**Subject: Advice in relation to the Moolarben Coal Complex OC3 Extension Project, Predicted Greenhouse Gas Emissions**

The DPE Science, Economics and Insights Net Zero Emissions Modelling team (NZEM) provide advice in relation to the Greenhouse Gas (GHG) emissions assessment for the Moolarben OC3 Extension Project (the Project). We have undertaken a high-level review of the key documents provided for our consideration in Appendix 1. A summary of our findings and recommendations follows.

### **Greenhouse Gas assessment in Appendix J prepared by Yancoal with calculations performed by Todoroski Air Sciences in Attachment 1 – final version 27 October 2022<sup>1</sup>**

Figure 2-3. Thermal coal production profile (2025 to 2034, Mtpa) – Project

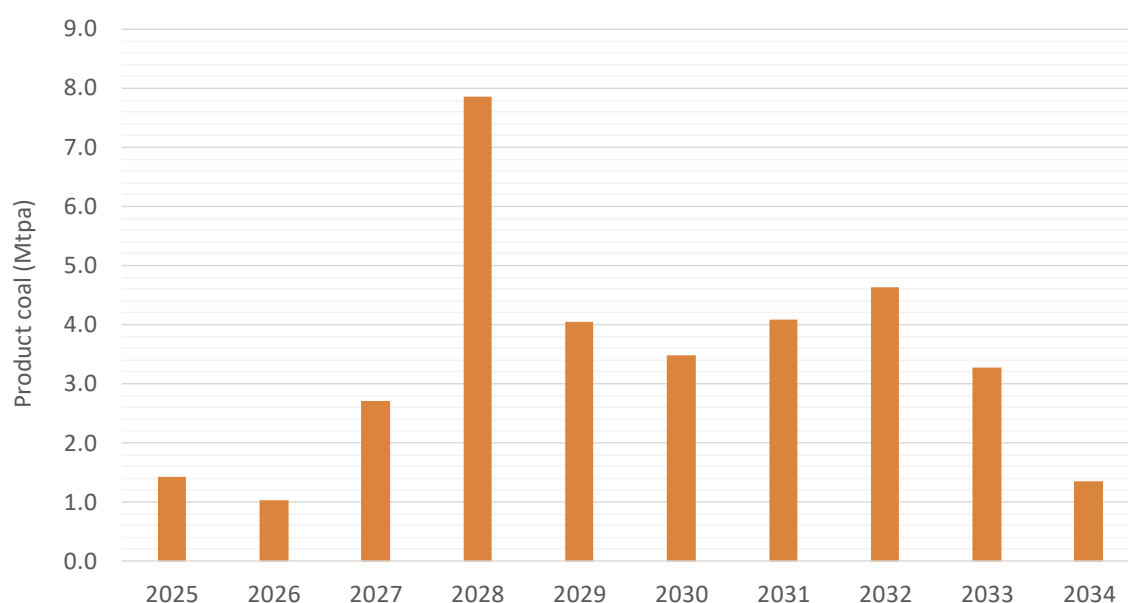
- I. More detail is required on the diesel consumption associated with the Project. The use of a single activity factor for diesel consumption leads to discrepancies between reported values and those derived by NZEM. Having more detailed information on the sources of diesel consumption will better inform potential abatement measures.
